Our Ref: 17106
10 May 2017

RE: BALLINA PUBLIC SCHOOL

Further to your recent request, the Transport Planning Partnership (TPPP) has reviewed the traffic reports in relation to the above school and their subsequent letters addressing several authority responses.

**1 A-002 SITE PLAN**  
1 : 400

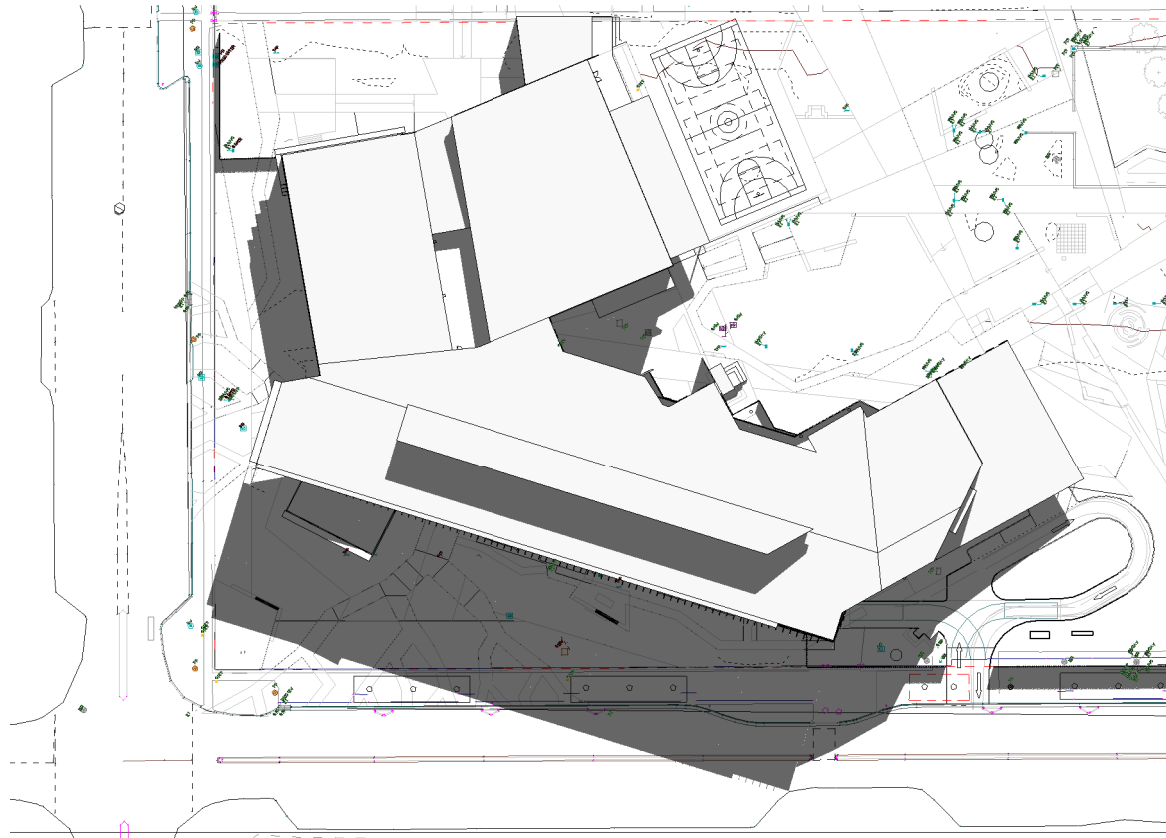
RMS's response requires the traffic report to be updated to address some of the issues raised in their letter but also, more fundamentally requires 110 parking spaces to be provided on site.

The proposal seeks to remove all on-site car parking spaces, which will transfer all existing parking demand onto surrounding local streets. The *Interim Guidelines for the Planning and Design of School Traffic and Pedestrian Facilities* recommends the provision of adequate on-site parking and that the design of the school should provide for the appropriate separation of pedestrians and cyclists from vehicular traffic. Further consideration should be given to providing on-site parking to reduce pedestrian activity on surrounding streets and minimise interactions between people and vehicles.

Roads and Maritime surveys of NSW schools has identified average car parking rates of approximately 0.11 per student. This would equate to an average demand of 110 parking spaces required for the proposed development, which is significantly higher than the 70 spaces identified in the supporting TIAs.

The supporting TIAs identify the parking capacity on surrounding streets, but not the existing peak hour demand generated by nearby developments. Further assessment is required to determine whether sufficient peak hour capacity will be available to accommodate the cumulative parking demand of existing and proposed development in the area.

Whilst the servicing and surrounding street system has the capacity to safely handle the traffic generated by the redeveloped school and the future indoor sports and community centre should it proceed, the submitted plans to remove all off-street parking from the site and provide for the school's teacher, student, and visitor parking, set-down and pick-up, entirely within the surrounding streets is unacceptable. The application's proposed approach would create a severe and avoidable impact on the established amenity of residents living in the immediate locality of the school and to the current safety and availability of on-street parking servicing the existing adjacent sports and community facilities.

The Council supports the submission of NSW Roads and Maritime Services dated 31 January 2017 in its entirety and recommends as an essential element that any consent issued be conditioned to require the provision of a minimum of 110 off-street parking spaces for the school (preferably having access from Cherry Street). These spaces should include the provision for weather protected disabled parking in accordance with the Australian standards to assist students, staff and visitors to the school.

Ideally, pick-up and set-down facilities for students should also be provided on-site as opposed to within the street system.

It is a fundamental requirement for new developments, particularly those that have the capacity to increase traffic and parking demand, to make proper provision for off-street parking and, simply, this application doesn't do so.

It is TTPP's view that it is not sustainable to provide 76 (or 110) spaces on site when there are some 90 regularly unoccupied parking spaces already provided around the perimeter of the site. These parking spaces clearly provide little benefit at the moment and their use, during school hours, would be a sustainable use of this parking. Furthermore, excavation of some 3000m² of a valuable site to re-provide these levels of parking on-site when there is available and unused parking space around the perimeter of the site is not sustainable. The use of this parking and the loss of these spaces to the wider public during school hours would be negligible as stakeholders, other than the school, do not appear to use these spaces to any great extent.

TTPP conclude that all of the parking requirements for the school could easily be provided in parking areas already located around the perimeter of the site. It seems unsustainable to build a car park on site of between 76 and 110 spaces in site in order to replicate these 99 unused parking spaces around the perimeter of the site. There is little current demand for these on-street parking spaces – what little demand there is during the day is probably as a result of parking demand at the school – and it is my view that other stakeholders would not be affected by the school using these parking spaces.
